**To:** FILE  
**From:** Richard Knowland  
**Subject:** Application ID: 2014-038  
**Date:** 5/6/2014

**Comments Submitted by: Marge Schmuckal/Zoning on 5/6/2014**

SHEET NUMBER
C09
12 OF 113

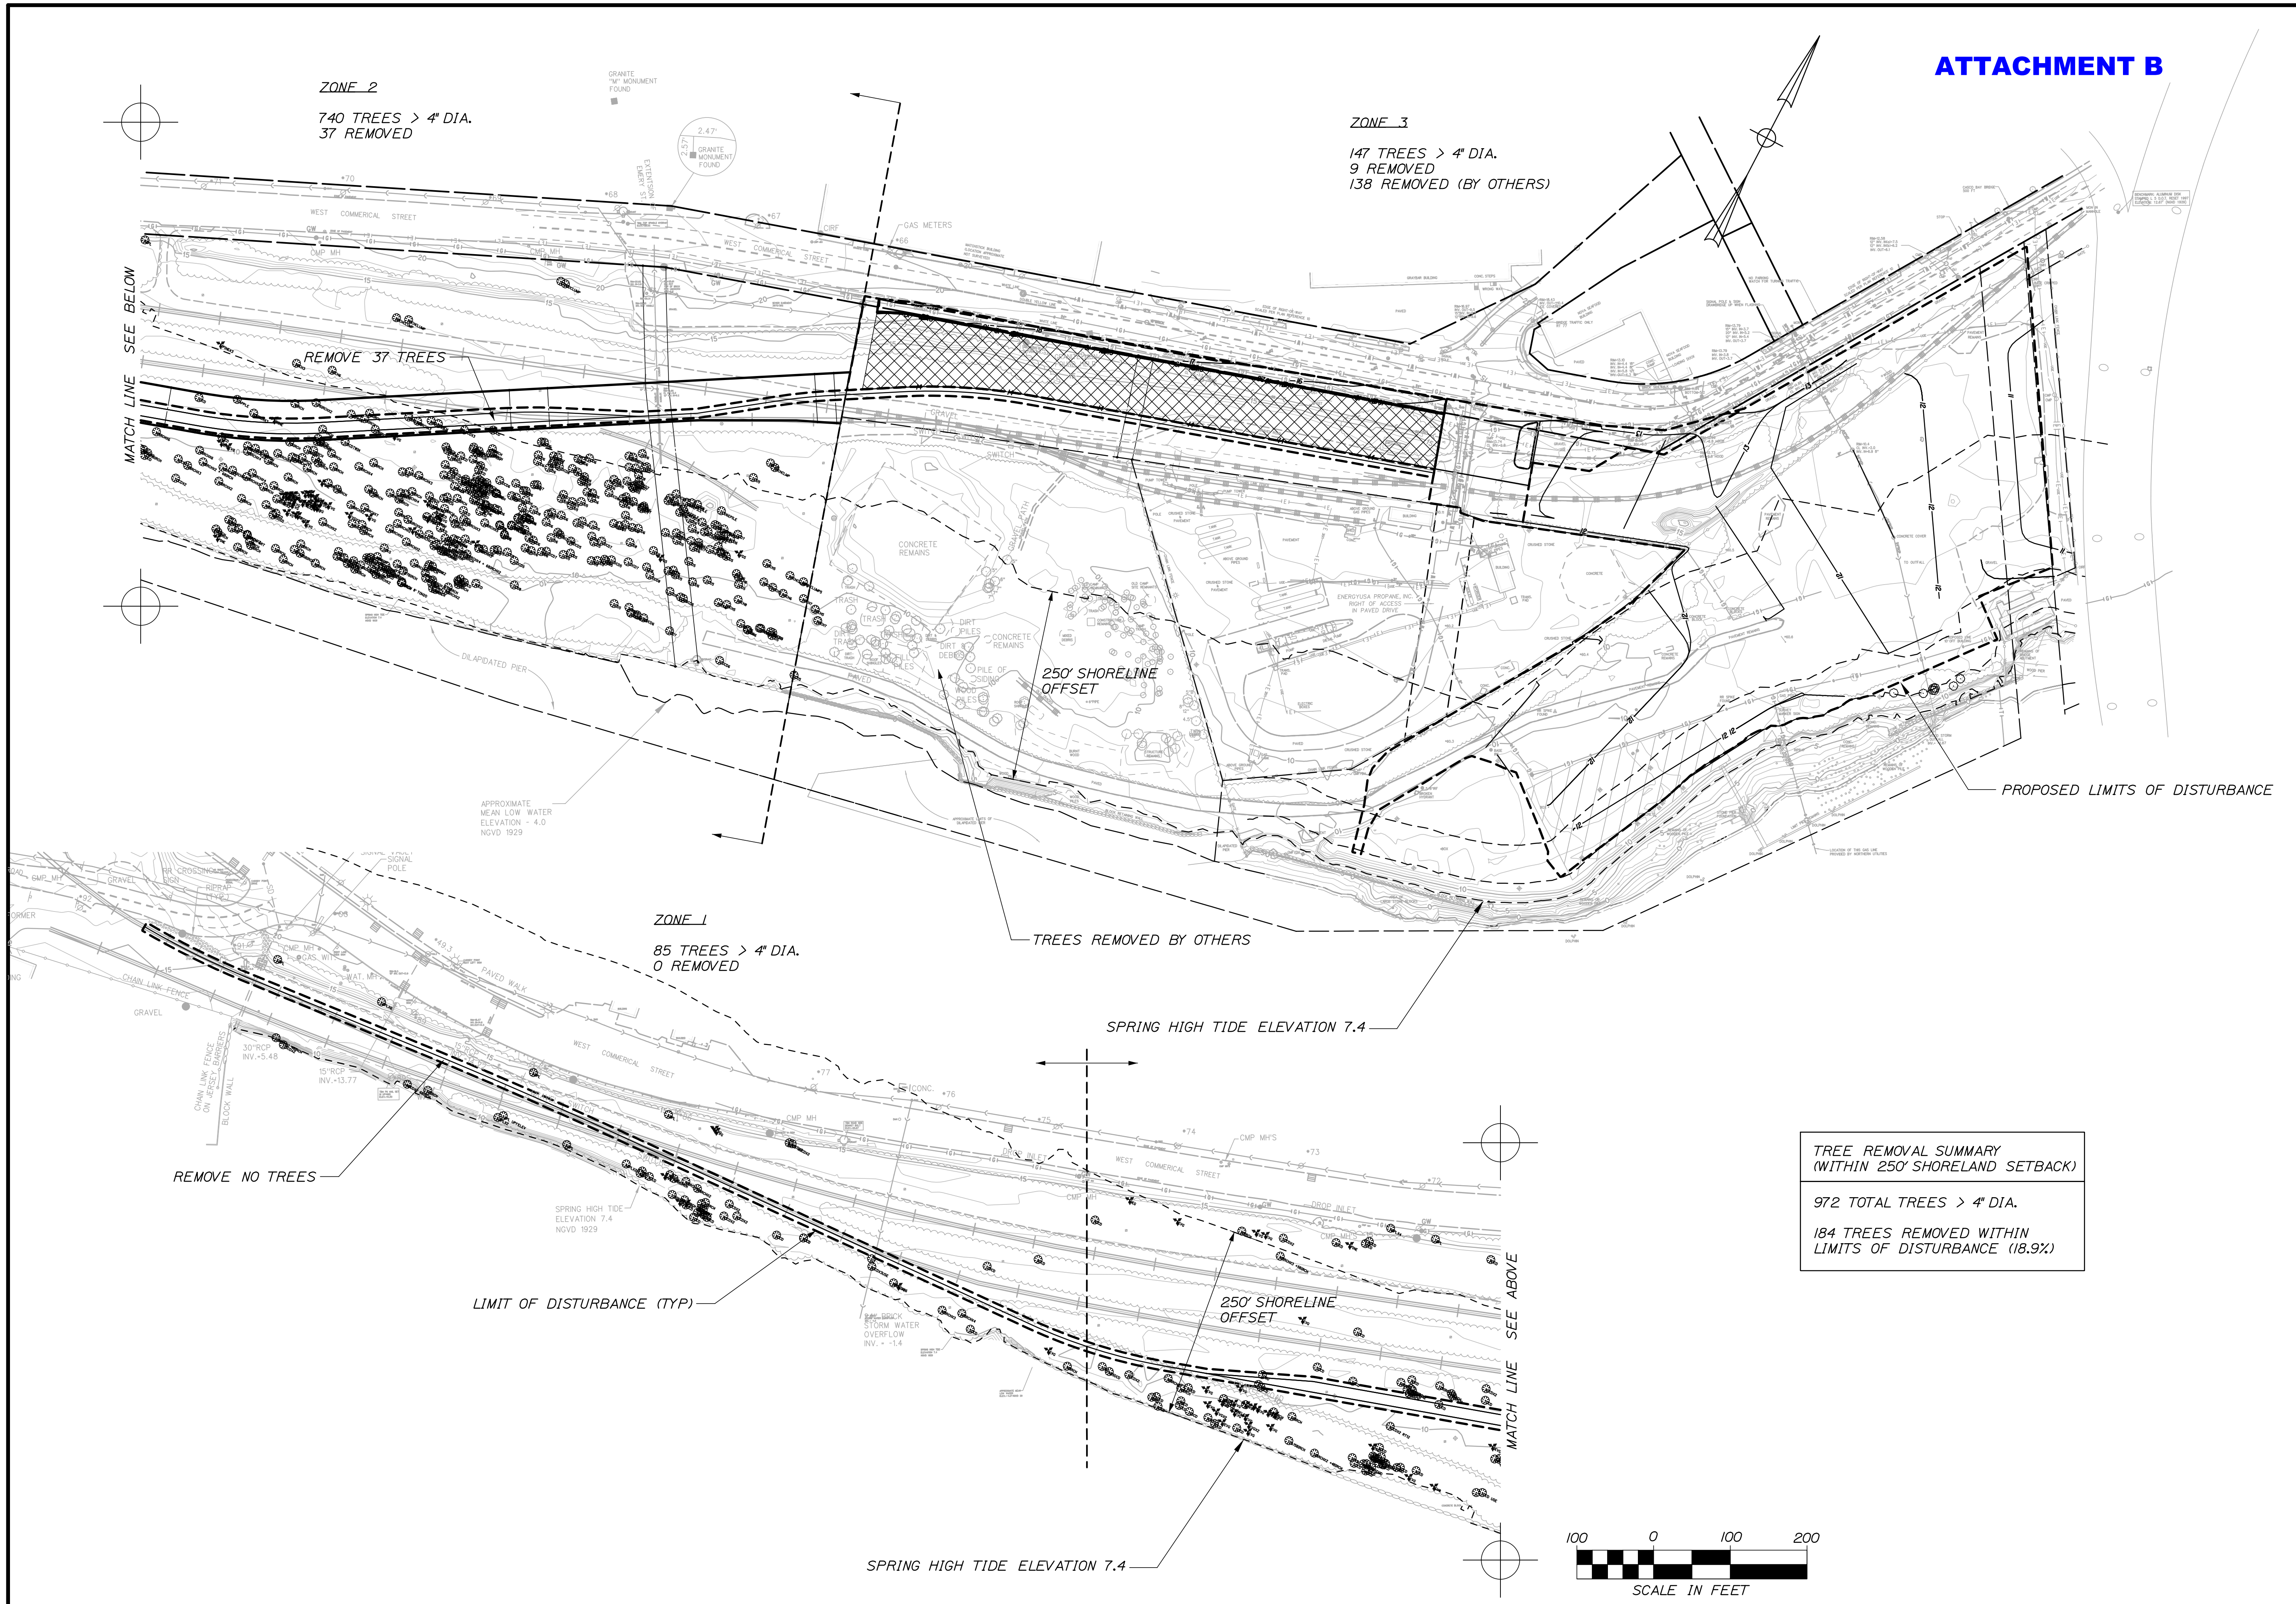
I also reviewed the submission concerning shoreland regulations. There is information concerning the clearing of vegetation. The verbage goes on to say "see enclosed plans for specifics." I did not find an enclosed plan that related to what was written. Please provide such plans or indicate which plan it is within the submission, so I can review compliance with our Ordinance.
